Please ask for: Nicola Moore
Email: nicola.moore@arun.gov.uk
Telephone: Ext 37944
Our Ref: CM/33/20/PL
Your Ref:
Date: 23rd September 2020

Application for Planning Permission

Proposed Shed / Garage 1:

Location: Church House Church Lane Climping BN17 5RB

SCALE 1:500

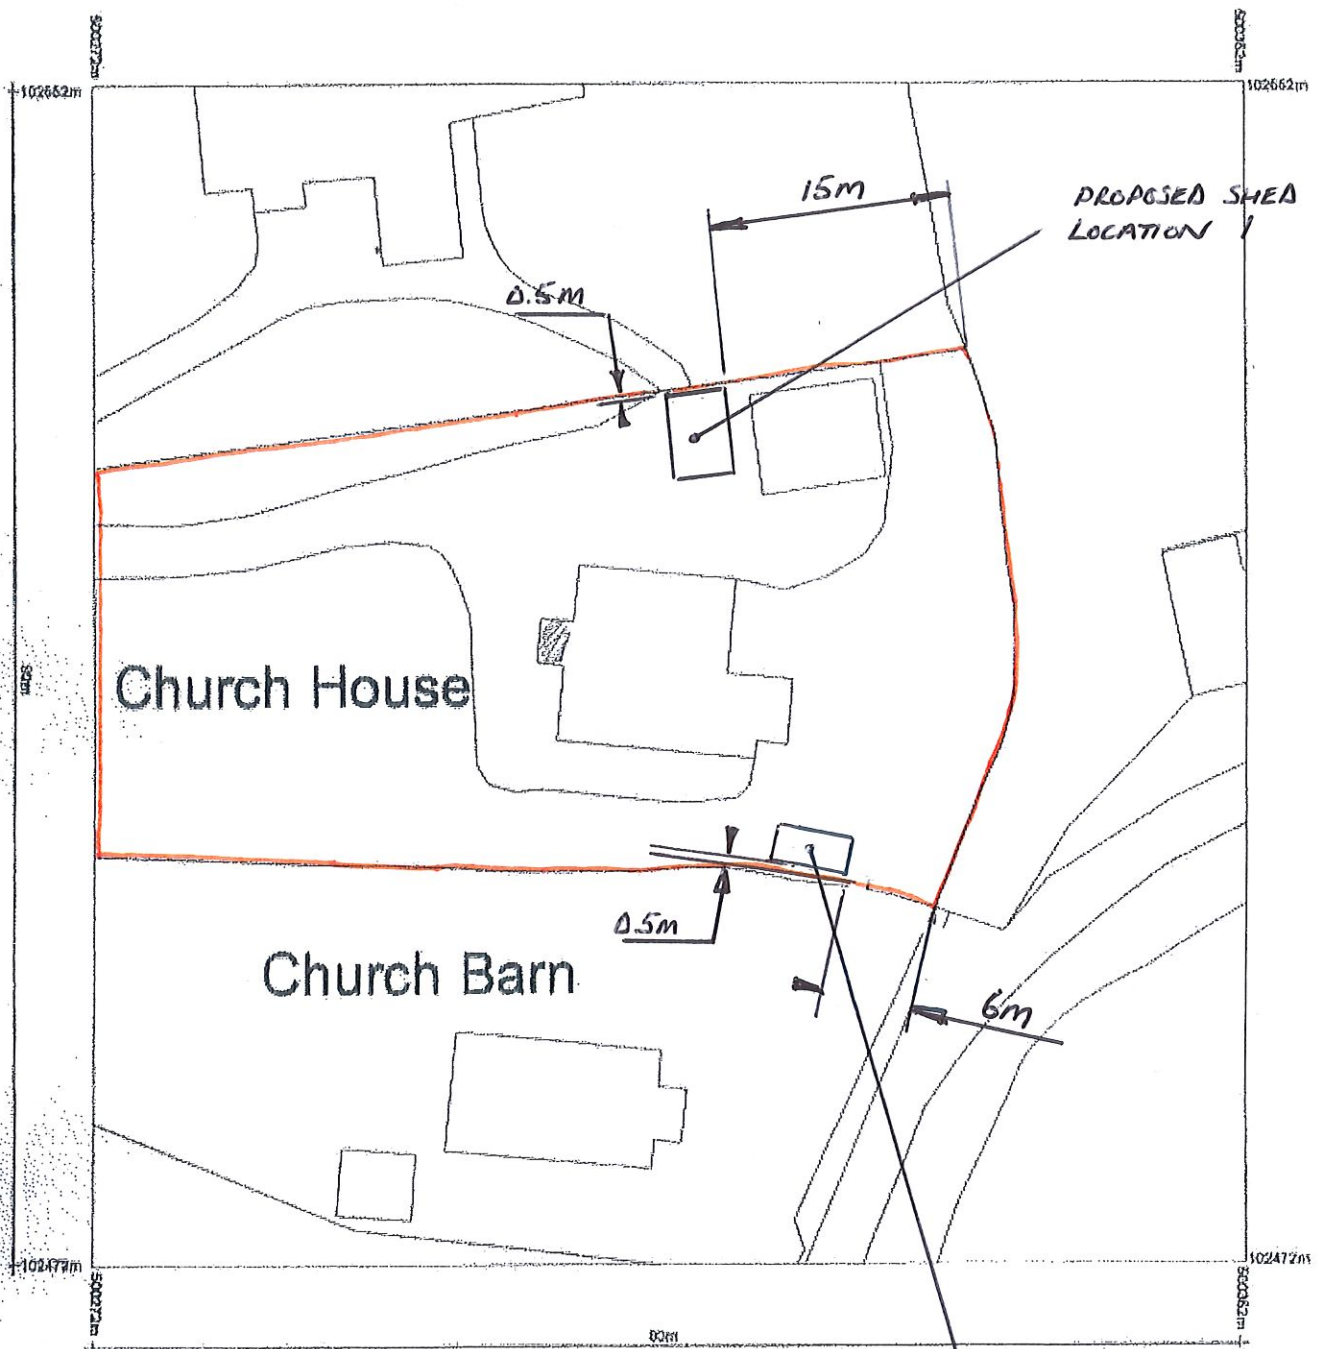
Block Plan

The submitted Block Plan does not scale/measure correctly at 1:500. Please check the scale, amend accordingly and re submit.
